# CITY OF ALBUQUERQUE

June 25, 2018

**RE: Yale Retail & Apartments  
416 Yale Blvd SE  
Grading and Drainage Plan  
Engineer's Stamp Date: 06/18/18  
Hydrology File: K16D011**

Based upon the information provided in your submittal received 06/18/18, the Grading and Drainage Plan **is not** approved for Building Permit and SO-19 Permit. The following comments need to be addressed for approval of the above referenced project:

C-1

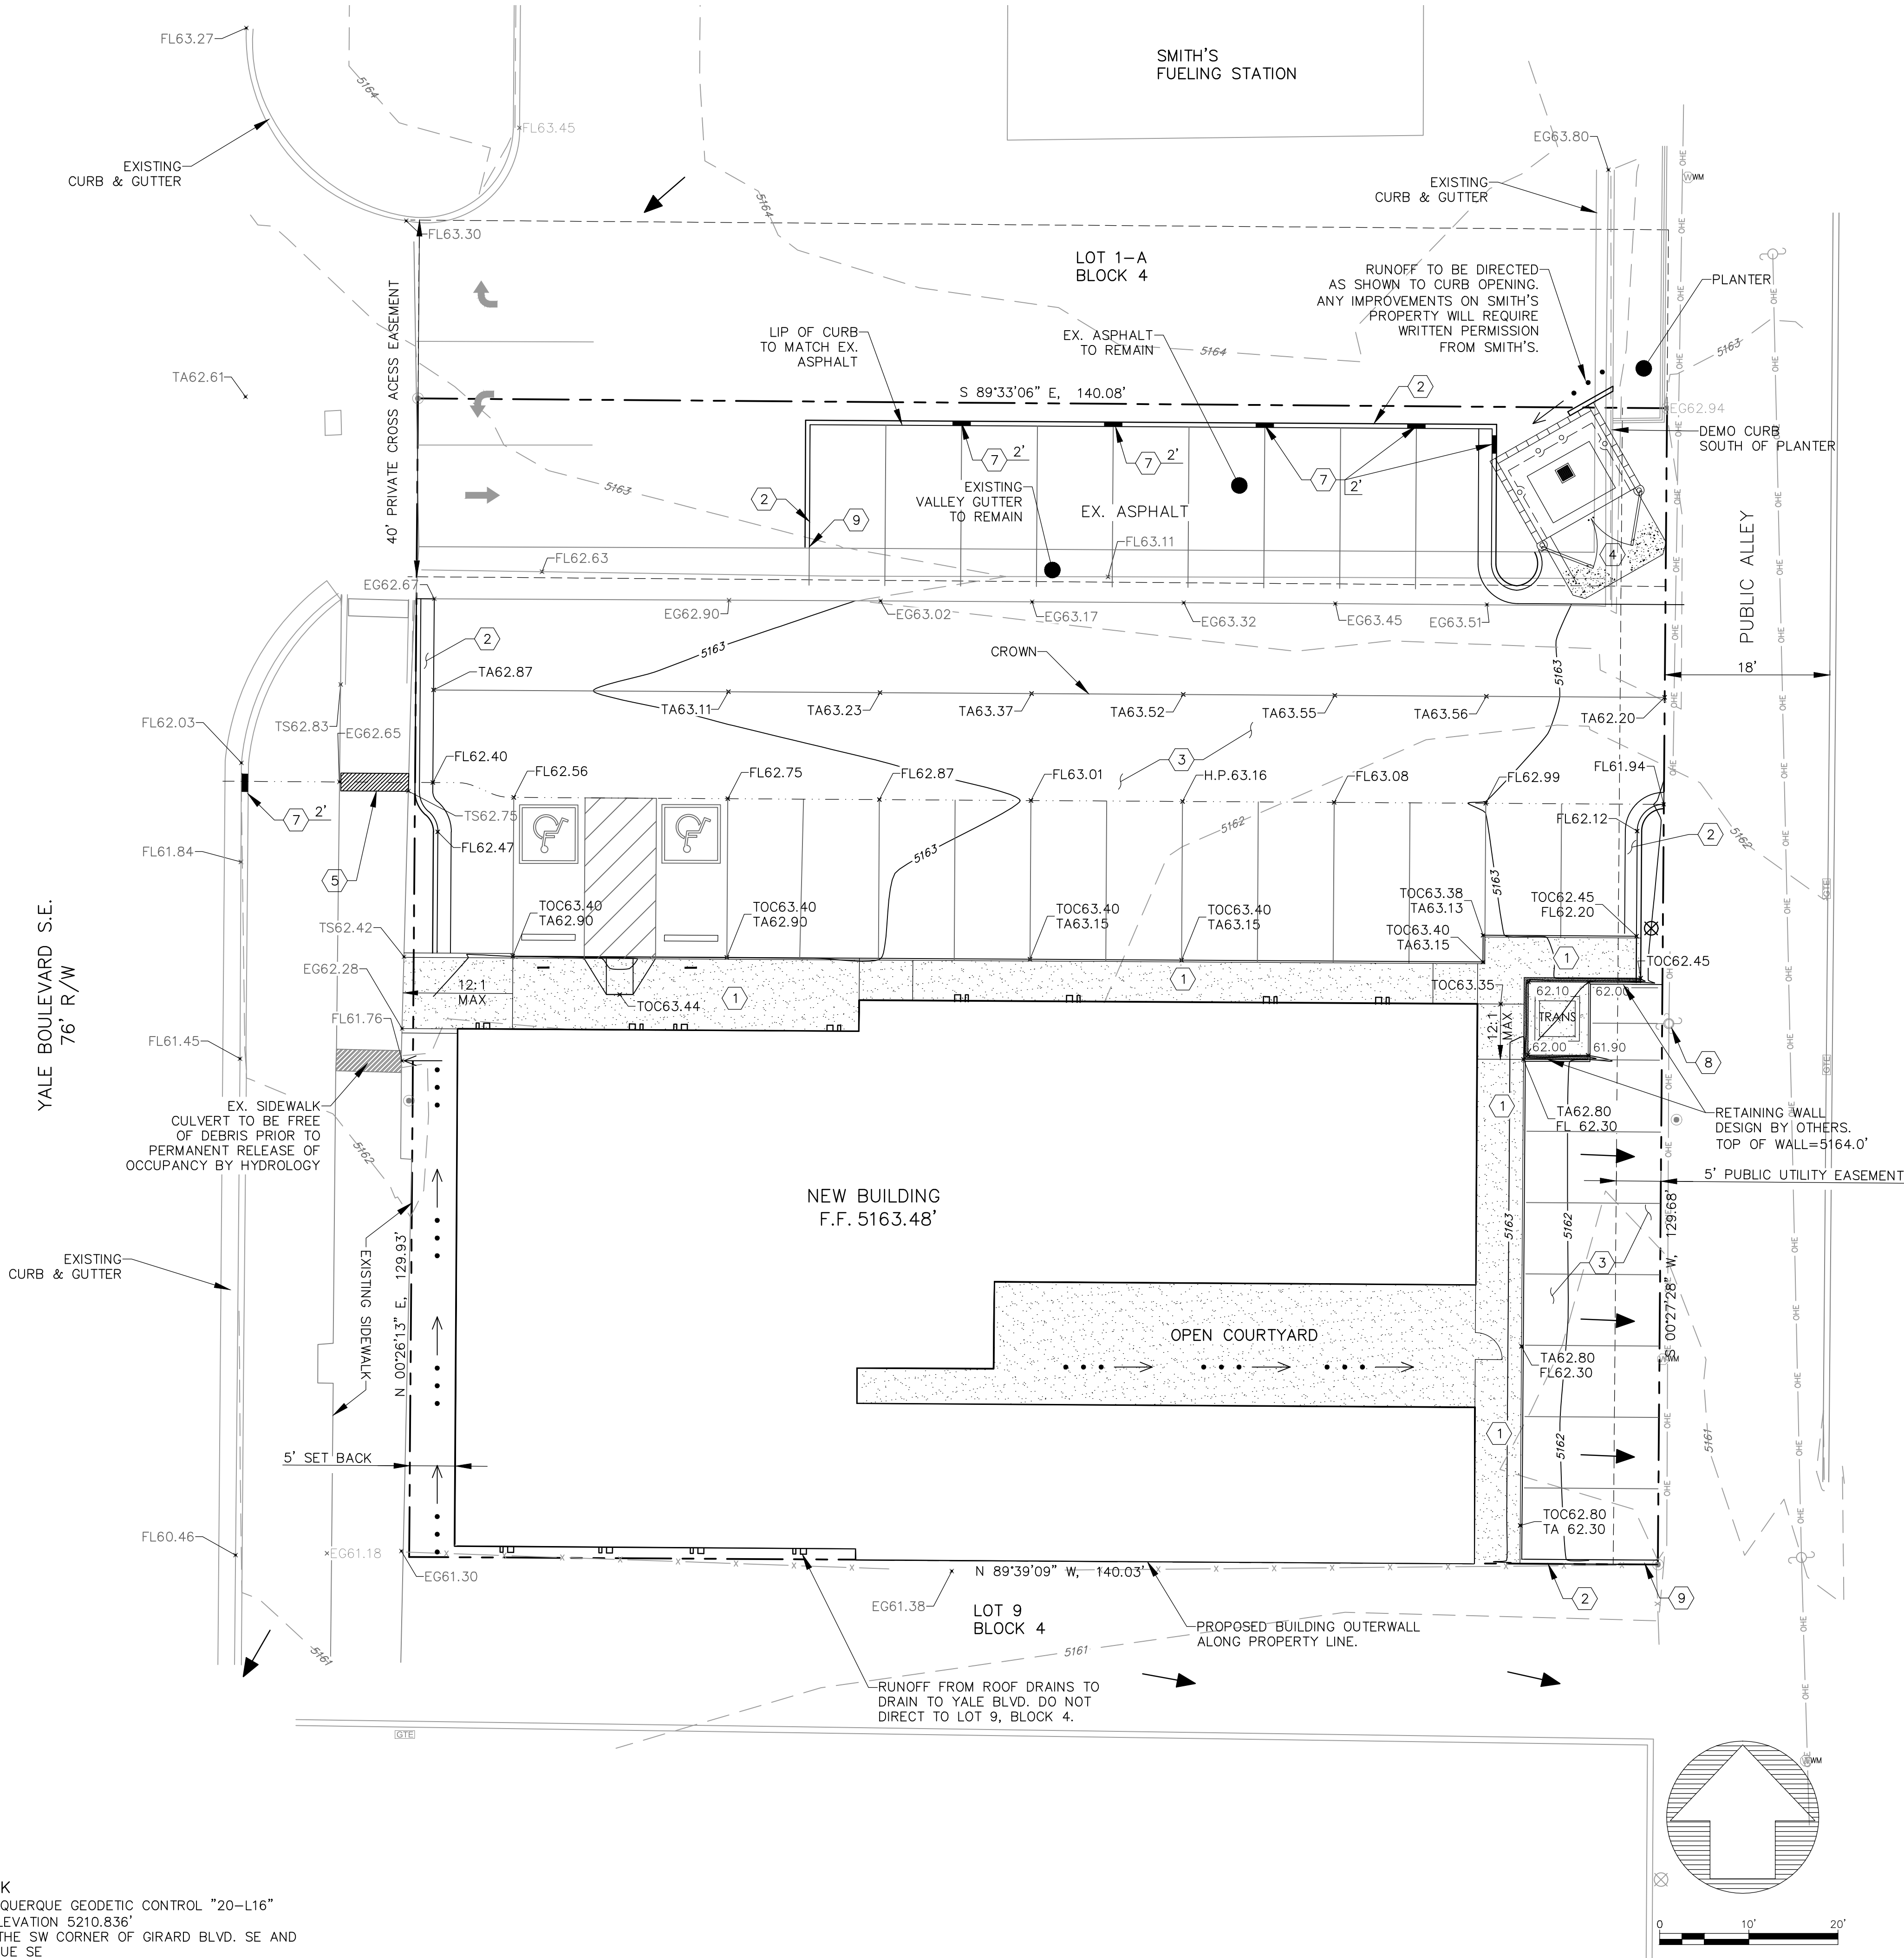
1. Sheet C-1. Please add a note to the existing sidewalk culvert, "Existing sidewalk culvert to be free of debris prior to Permanent Release of Occupancy by Hydrology.

2. Sheet C-1. At the southwest corner of the site there are too many contours with elevation 5161. It appears this area will drain from East to West towards Yale with elevations from 61.68 on the East side to 61.30 on the West. Please fix.

3. Sheet C-1. Please add the attached SO-19 notes.
4. Sheet C-1. The first flush volume cannot be provided within the drive aisle. The first flush must be in either a depressed landscaping area or an underground facility. If the site cannot support either, a Fee in Lieu must be paid for the required first flush volume of **424** cubic feet. The Fee in Lieu payment (Amount = 424 CF x \$8/CF = **\$3,392.00**) for the required first flush volume. If Fee in Lieu will be used, Then a note about this needs to be added to Sheet C-2.
